Architectural Design Report - Response to Submission

# UNSW Health Translation Hub

This report has been prepared on behalf of UNSW as an addendum to SSD 10822510 for the Health Translation Hub building.

The report has been compiled to respond to the design-related submissions received by the Department of Planning and Environment and Randwick City Council during the public exhibition of the UNSW HTH.

drawing
Shadow Analysis

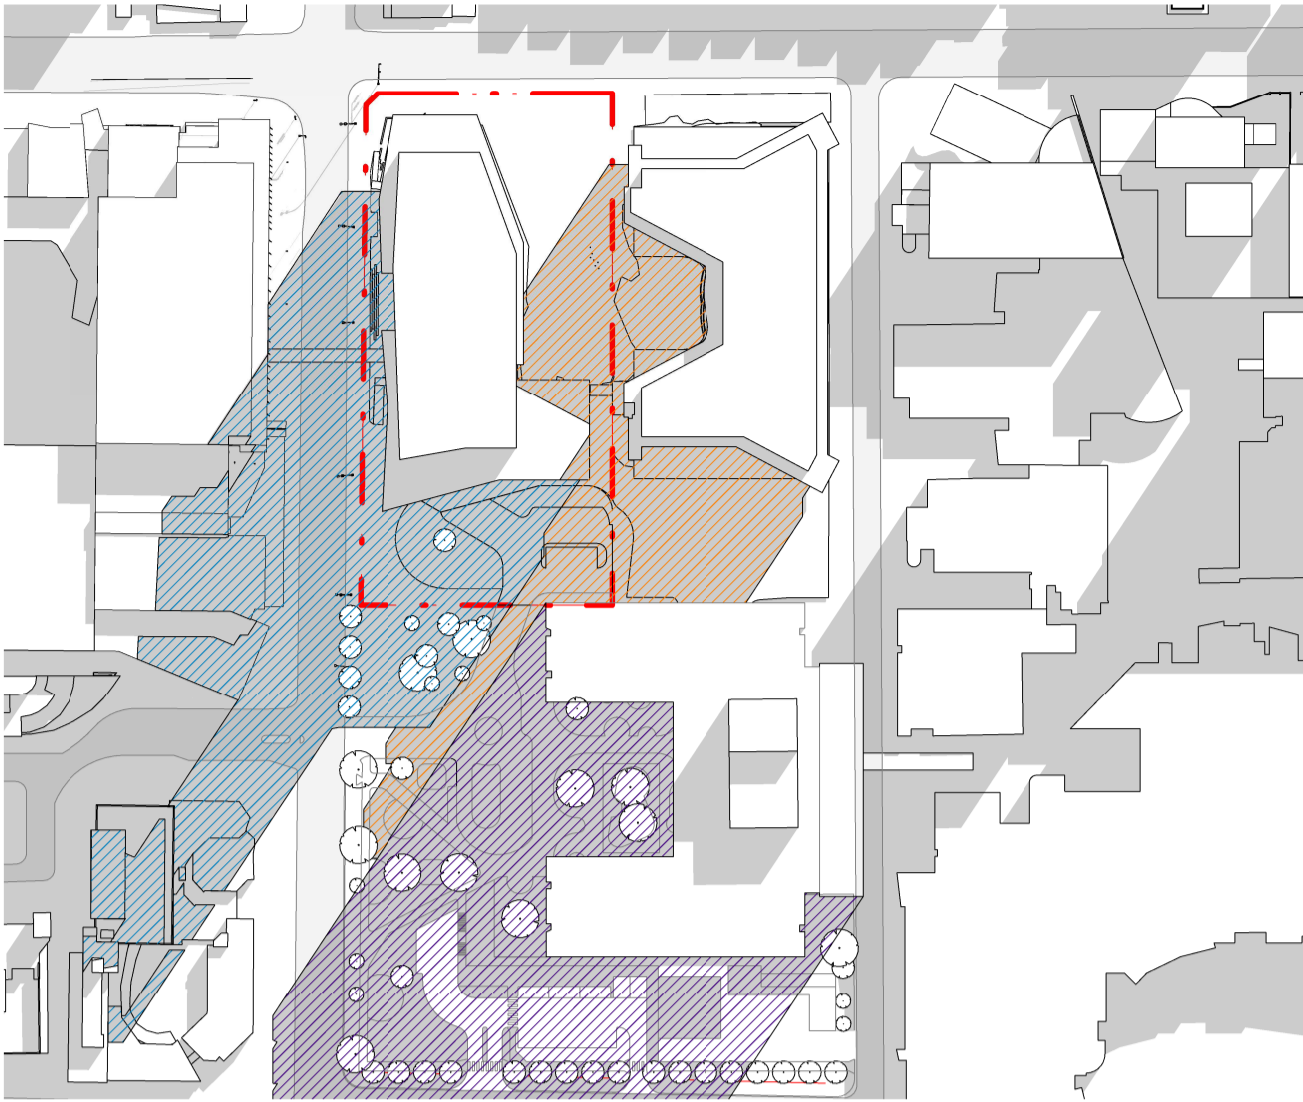
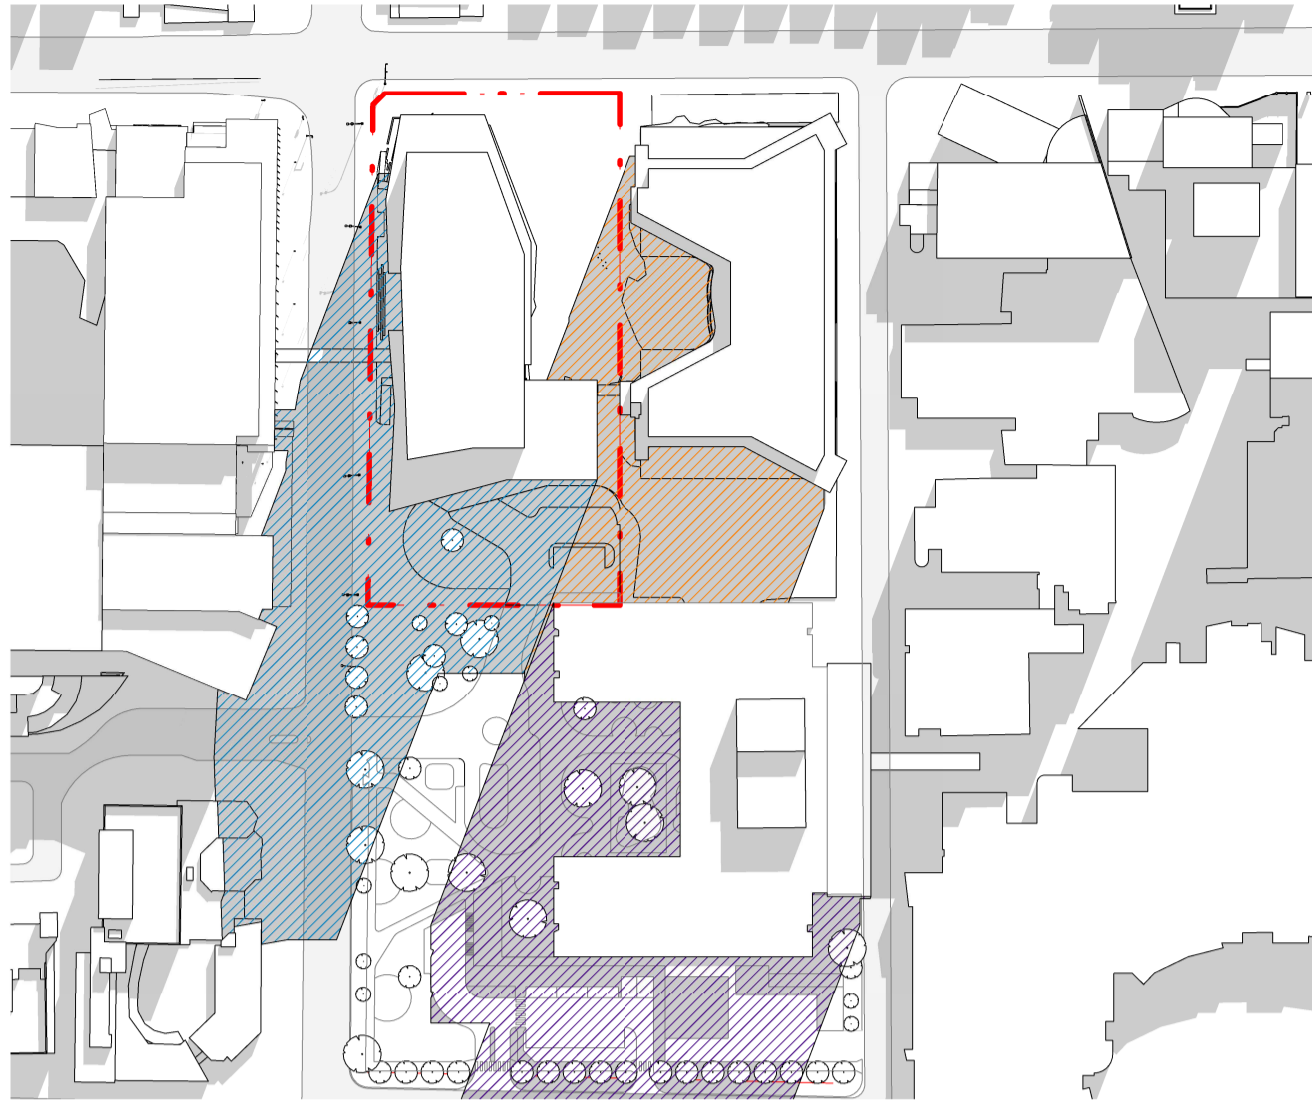
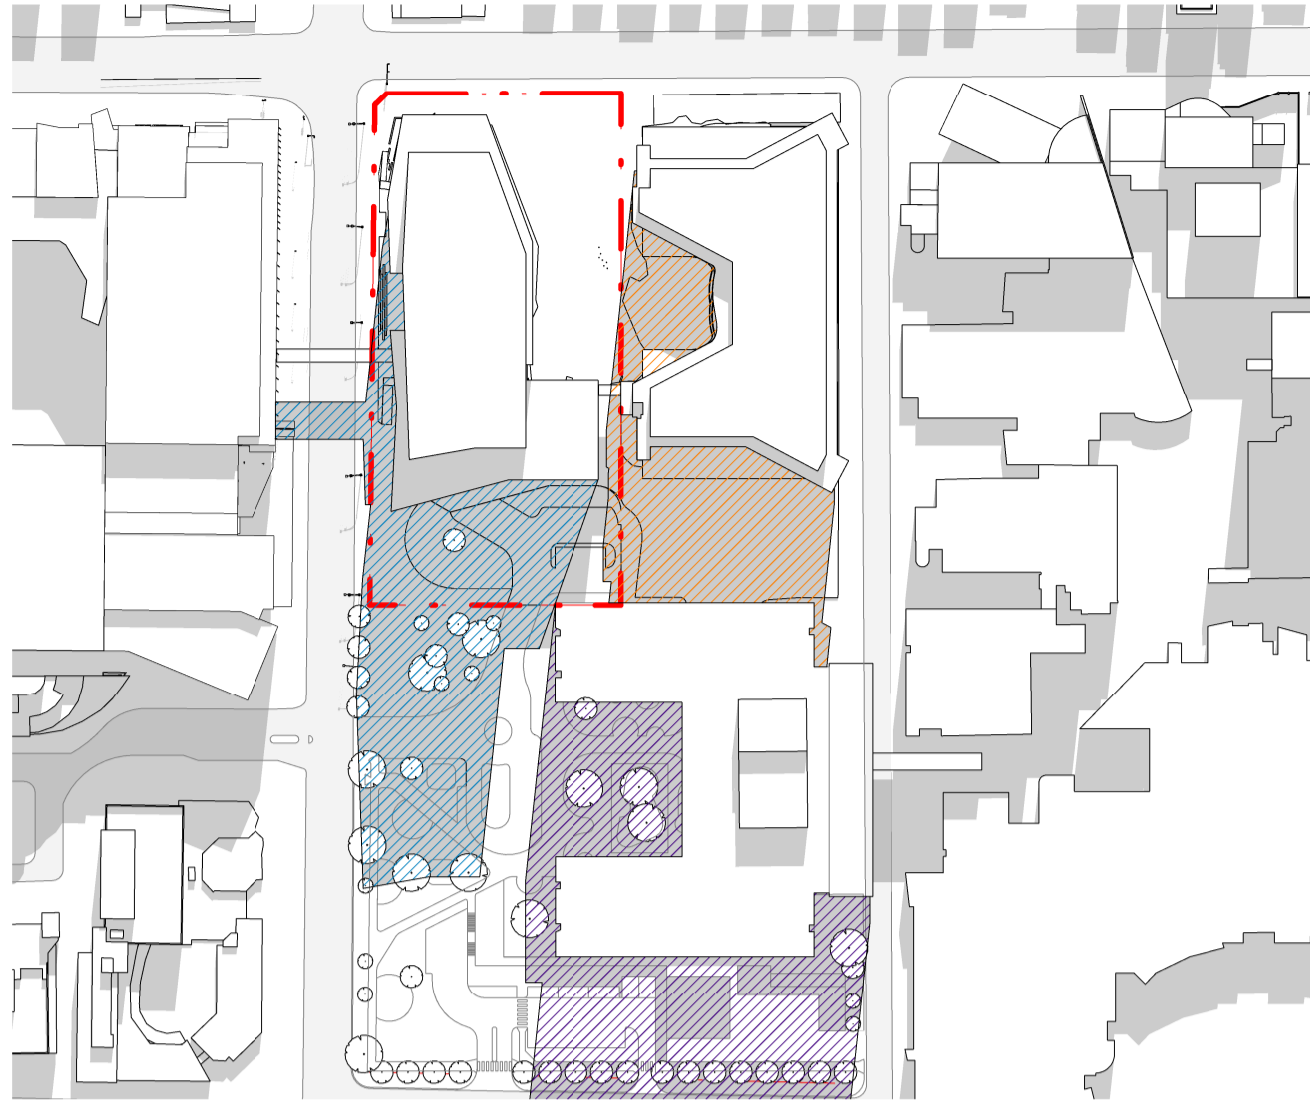
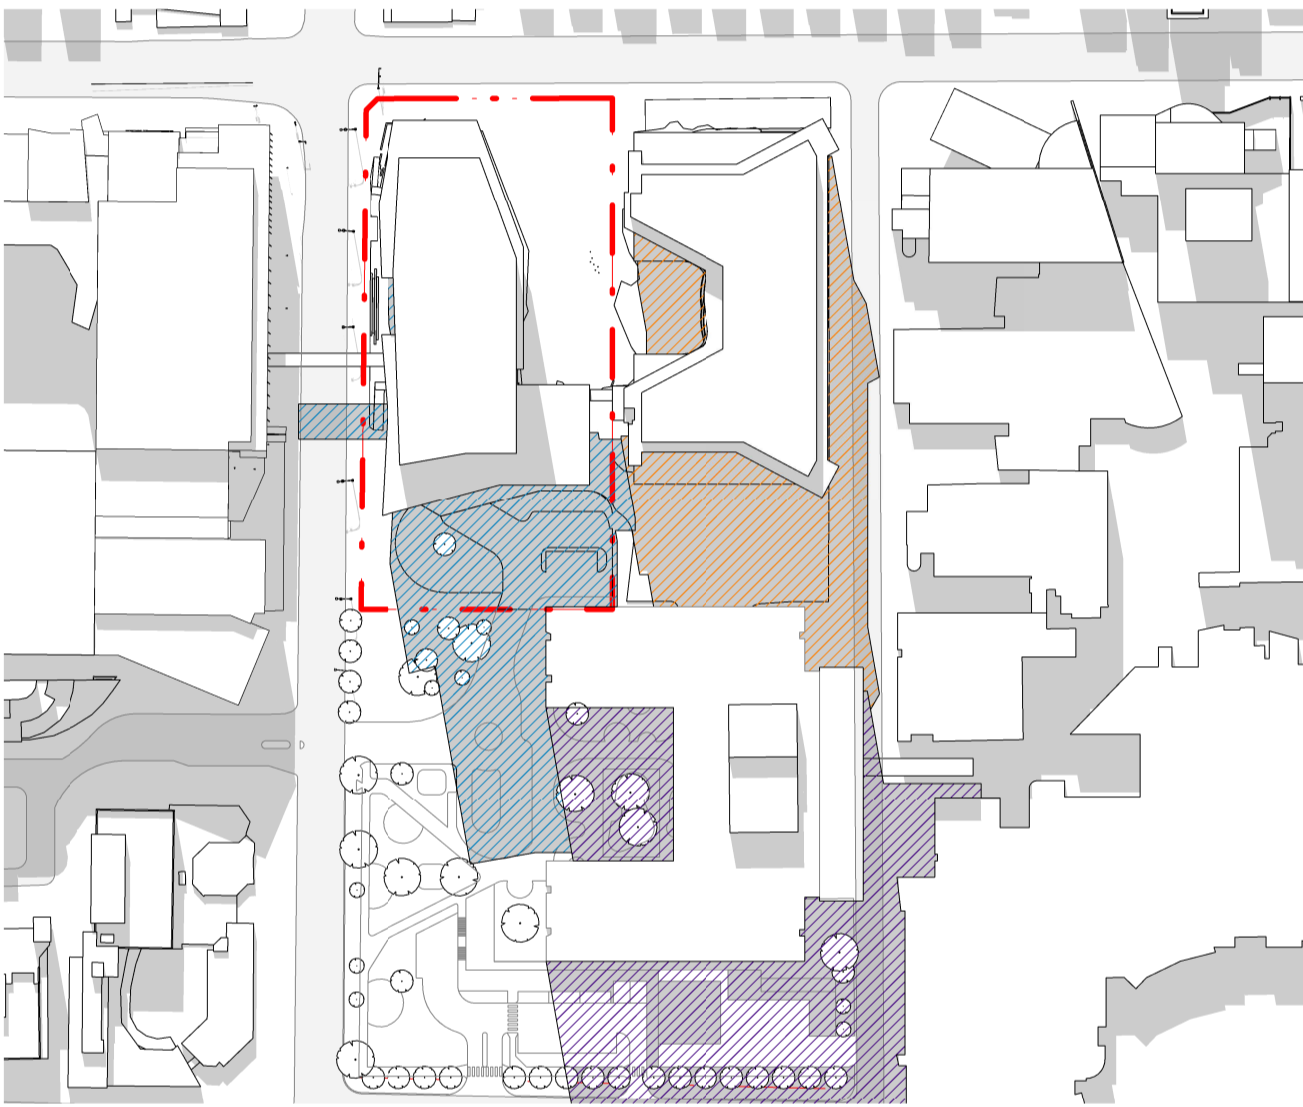
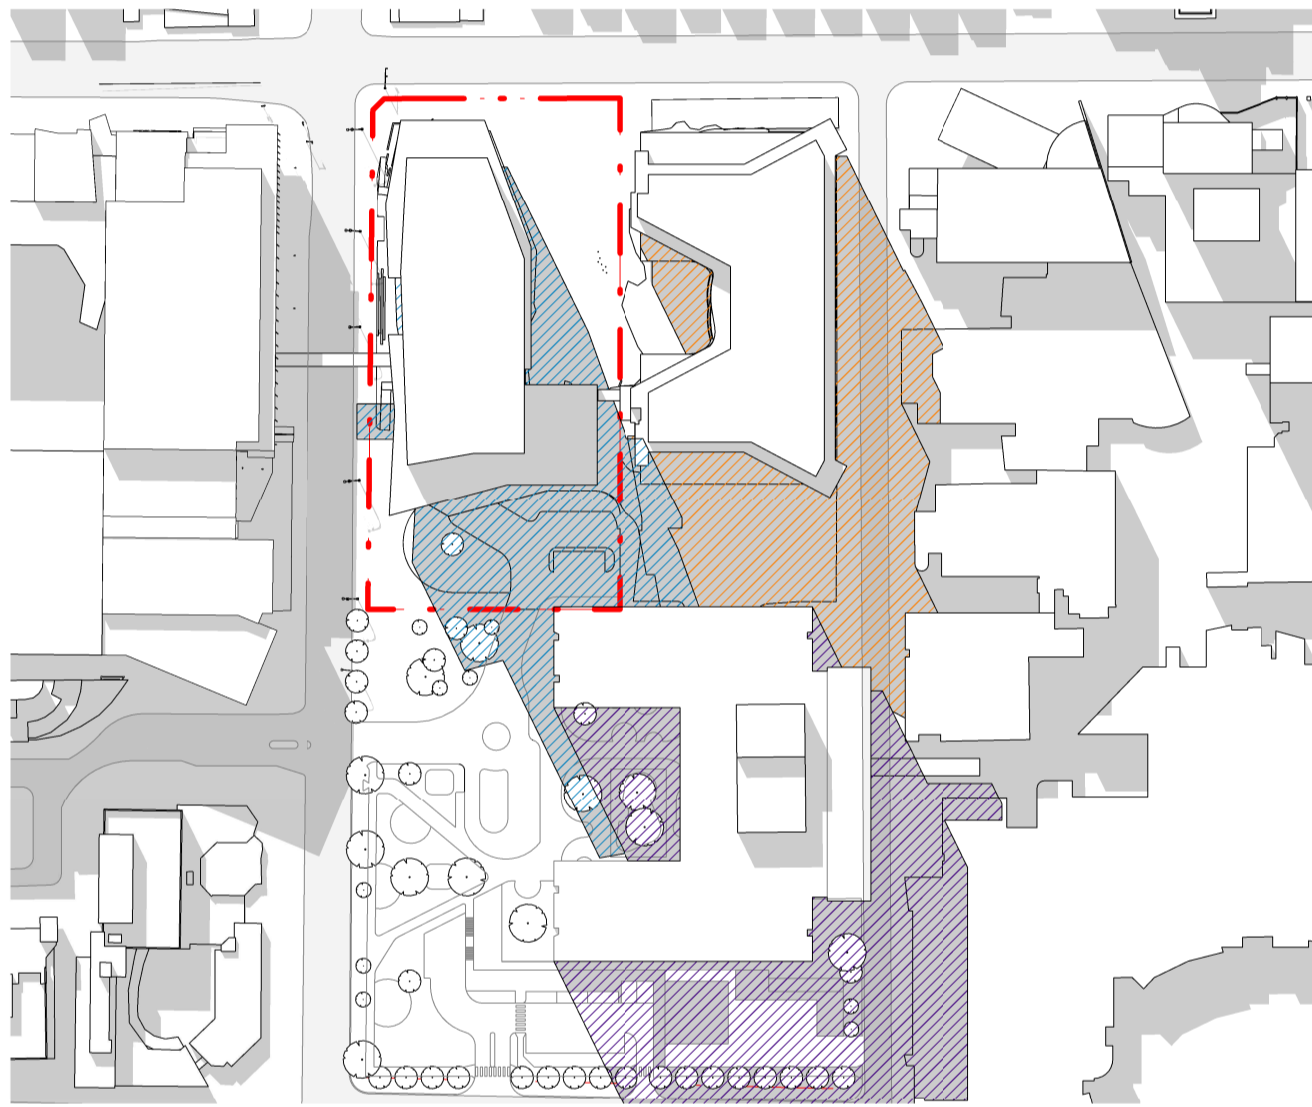
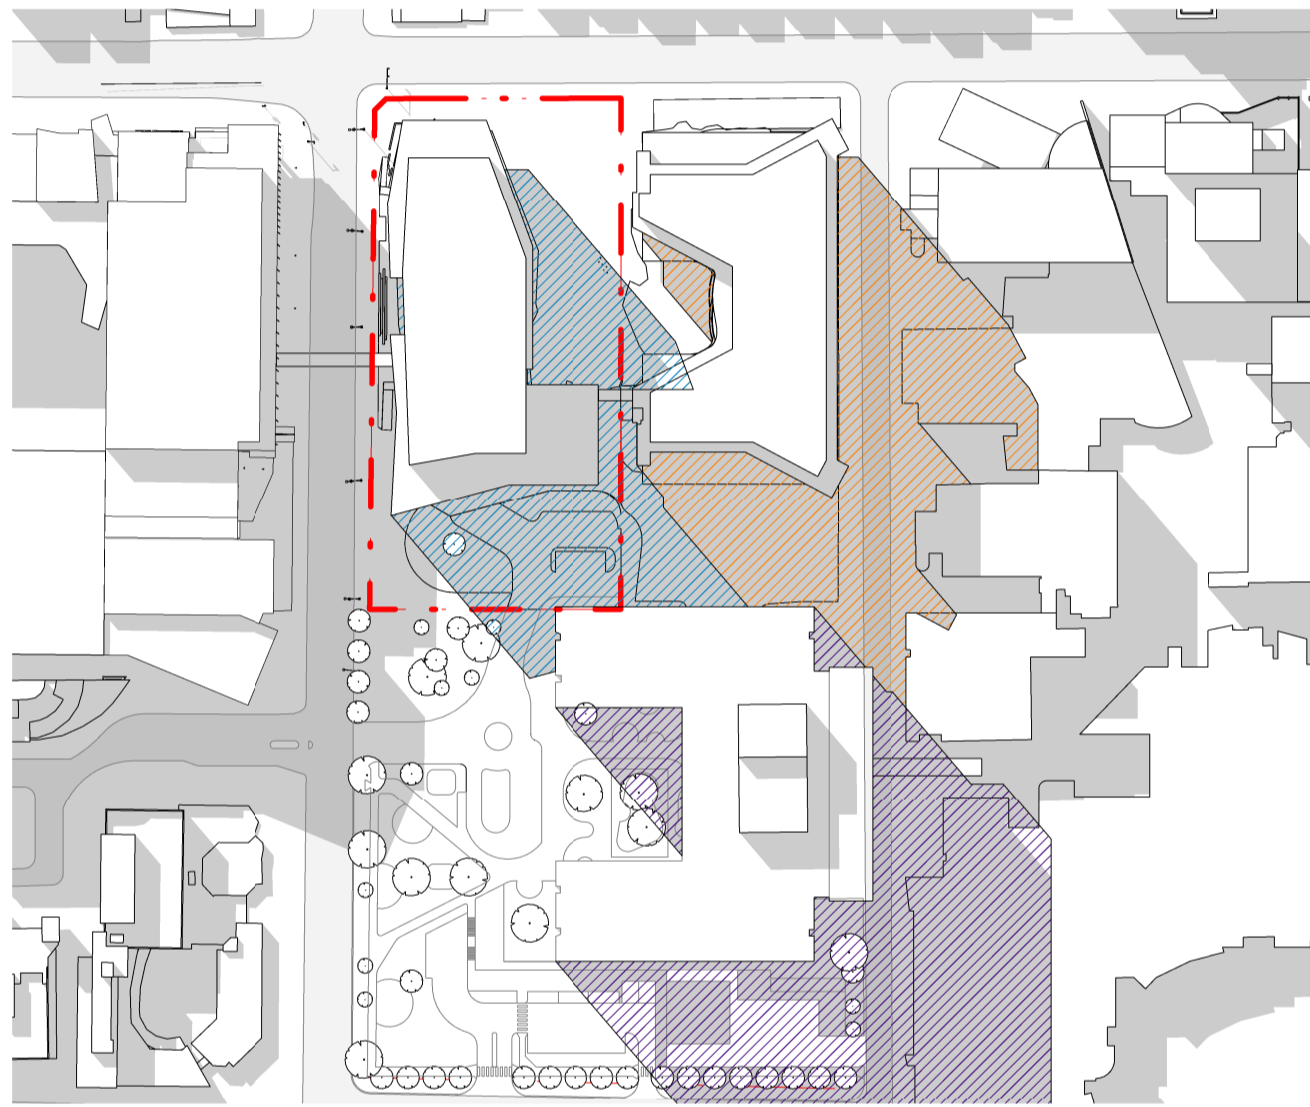
The shadow diagrams provided are limited, addressing only the early morning, midday and late afternoon. Hourly shadow diagrams at the June 21 should be provided to assess solar access and amenity.

Please find the additional shadow diagrams adjacent, and also included in Attachment A.
